# FORMAL OBJECTION REGARDING STATE SIGNIFICANT DEVELOPMENT (SSD-96272465) – 11-23 RANGERS AVENUE, MOSMAN

1 ELEVATION - SOUTH (RANGERS AVENUE)
SCALE 1 : 125

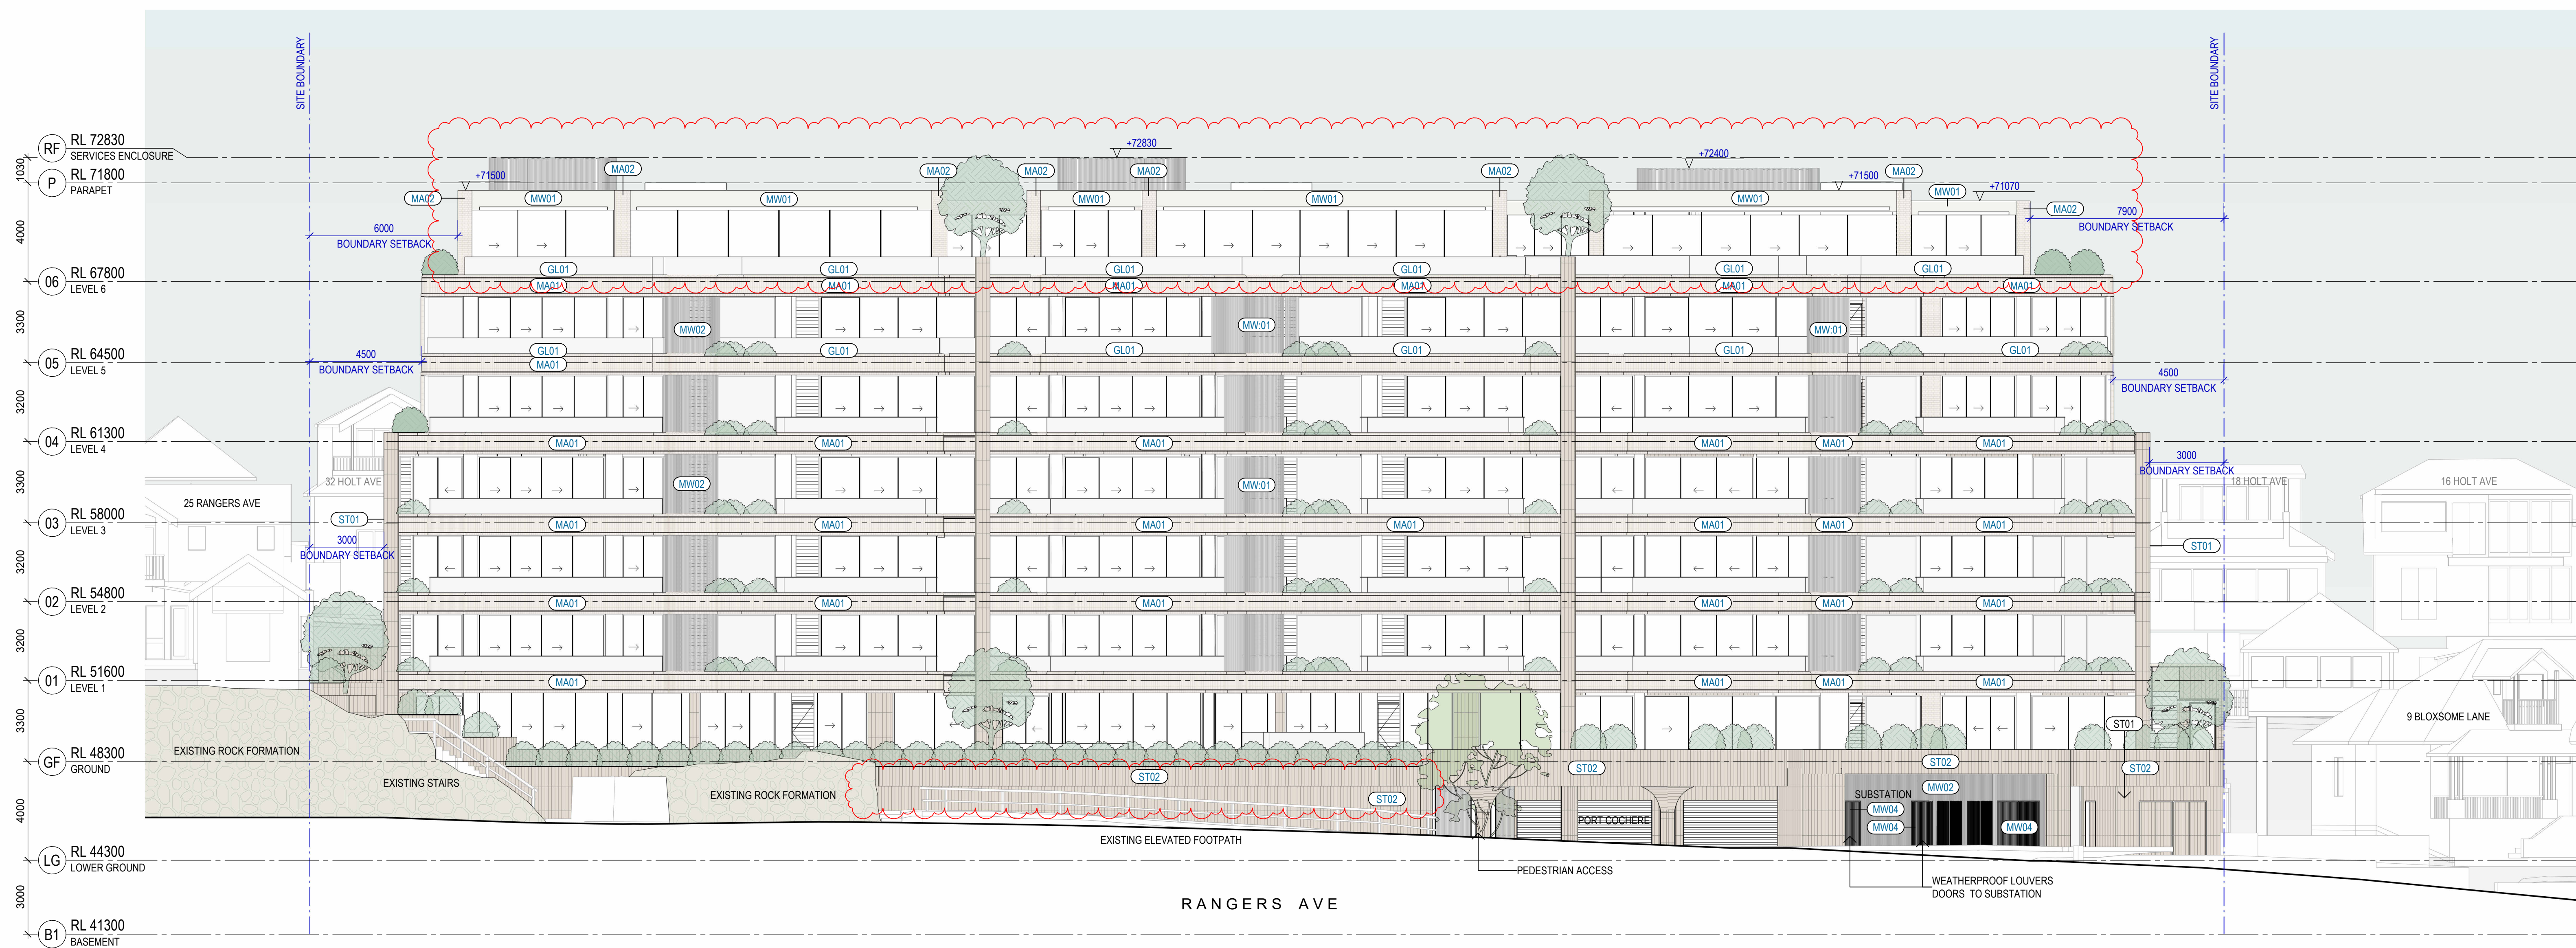
- c) Failure of Proportional Setback (ADG 2F & 2G): The General Elevations - South (DA3002) confirms the massing presents as a continuous, sheer wall running vertically from the Ground Floor up to Level 6 (Level 7 in the floor system). This design violates ADG Objective 2F (Building Separation) and Objective 2G (Street Setbacks) which require building separation to be increased proportionally to the building height and the upper levels to be recessed to achieve better amenity and privacy.
- d) Unmitigated Visual Bulk: The failure to introduce a substantial step-back at the mid-levels (such as Level 4) maximizes the visible bulk, creating an

unacceptable, monolithic structure that is contrary to the urban design principles of articulation and scale management in a sensitive transition zone.

1 ELEVATION - WEST
SCALE 1:125

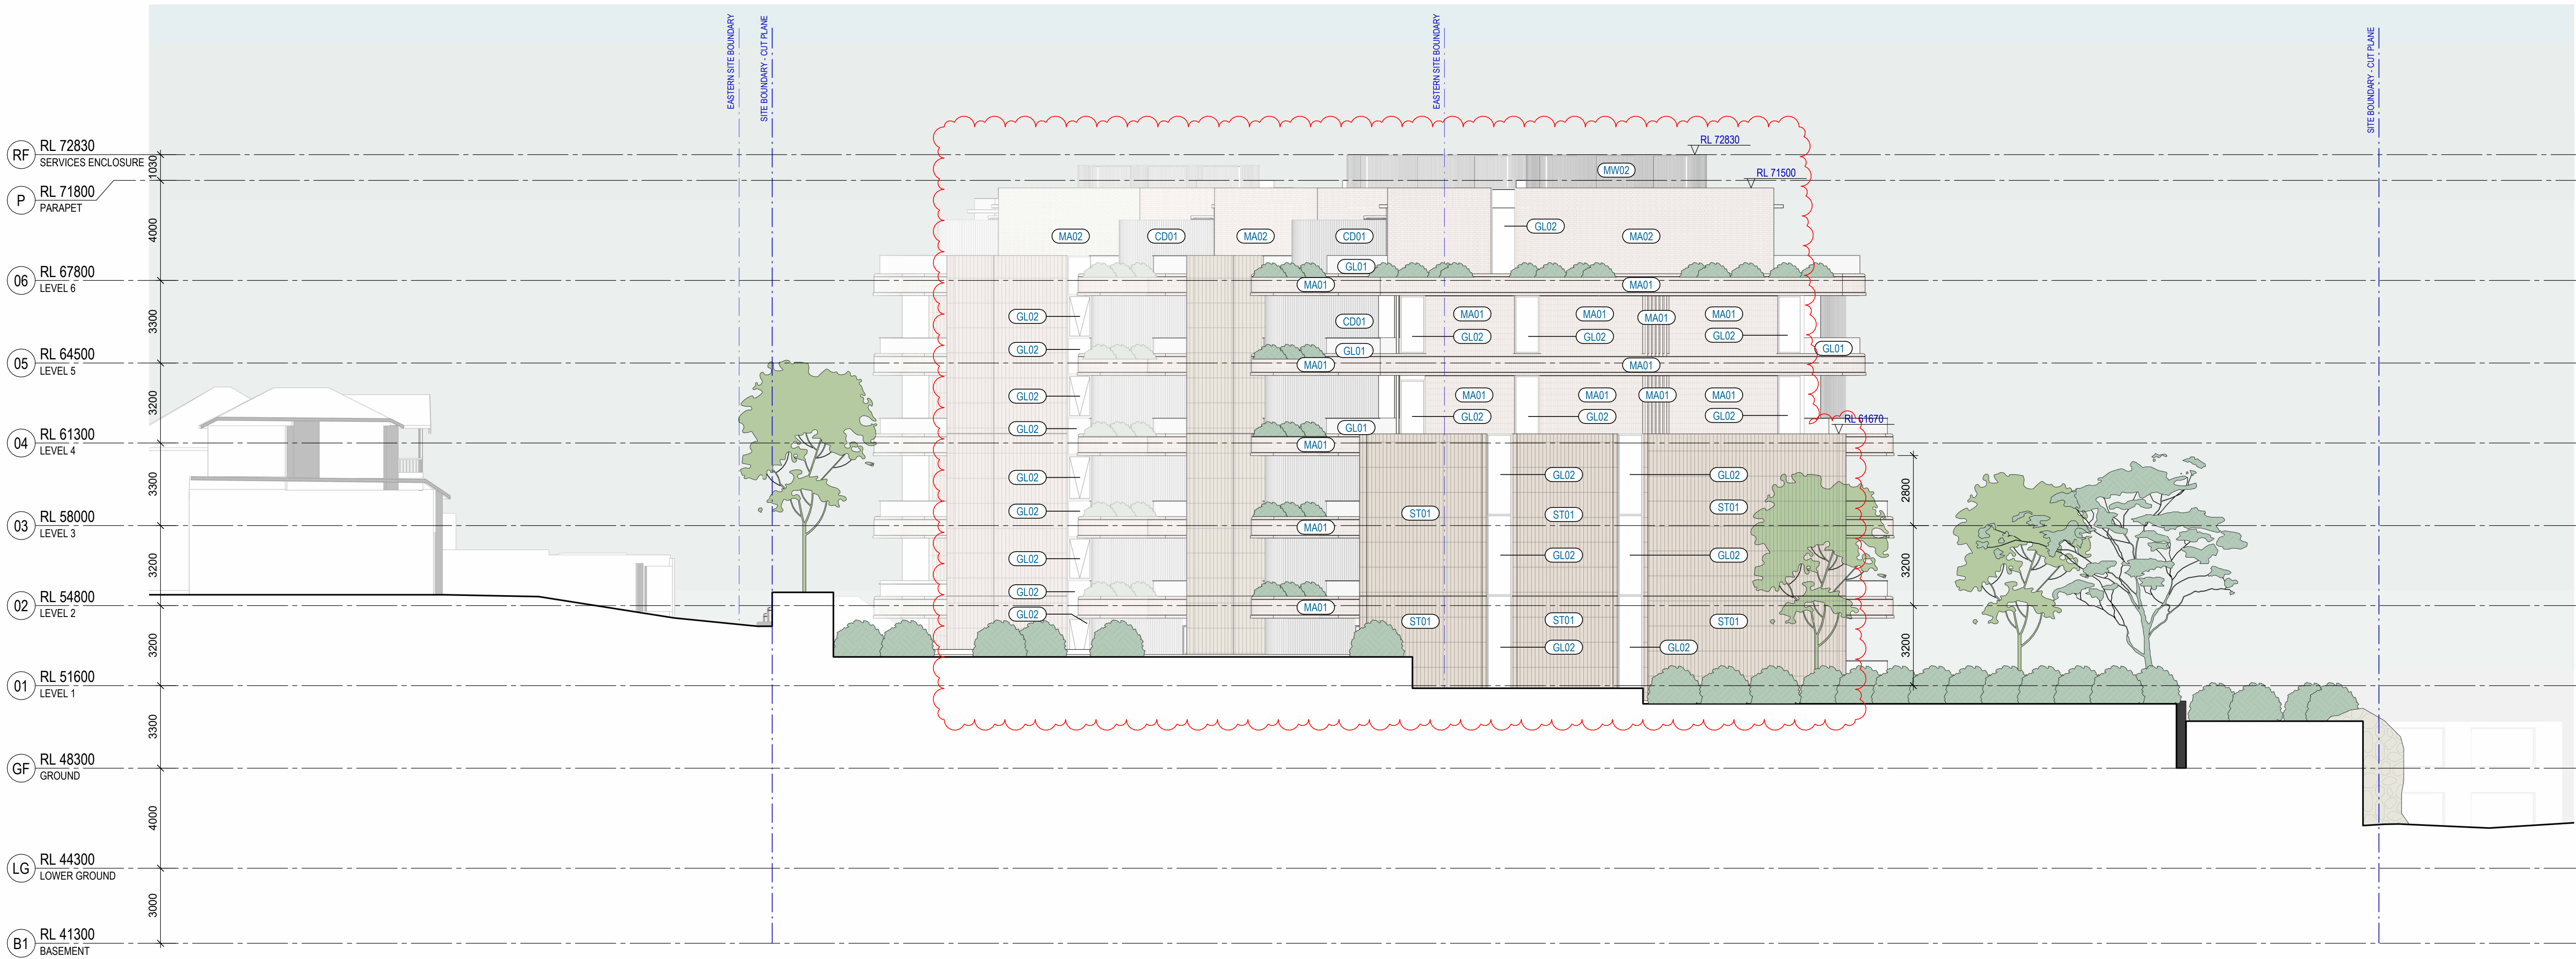
The insertion of an undocumented, structural opening—likely a utility access hatch, maintenance point, or basement ventilation light well—at the base of the western façade fundamentally invalidates the **Proponent's** entire strategy for managing the sensitive interface with 25 Rangers Avenue.

- ii. **The Breach:** The existence of a permanent **access point/hatch** at the boundary line directly next to sensitive areas (children's bedrooms, glass-roofed children's bathroom, and pool area) creates an unacceptable visual intrusion risk. This requires regular maintenance access, meaning workers will gain an unmitigated, direct line-of-sight into the highly private and vulnerable spaces of our home. This is a severe breach of **ADG Objective 3F (Visual Privacy)**.

- i. The **Proponent's** promise of a green buffer is predicated on the 3.0-metre setback functioning as a Deep Soil Zone for planting.
- ii. The structural requirement of this access point—which extends to the Basement/Lower Ground structure (RL 44300)—means that this area is now a permanent hardstand or structural element, directly contradicting the need for soil and the long-term viability of any large, mature tree planting. This reinforces the finding that the design **fails to meet the ADG's 6.0-metre minimum dimension for Deep Soil Zones**, rendering the entire vegetative screening claim null and void.

**Demand:** No structural openings, service access points, or ventilation apertures are permissible on the western boundary where they compromise the ADG's visual privacy and acoustic amenity standards for adjoining **Habitable Rooms**.
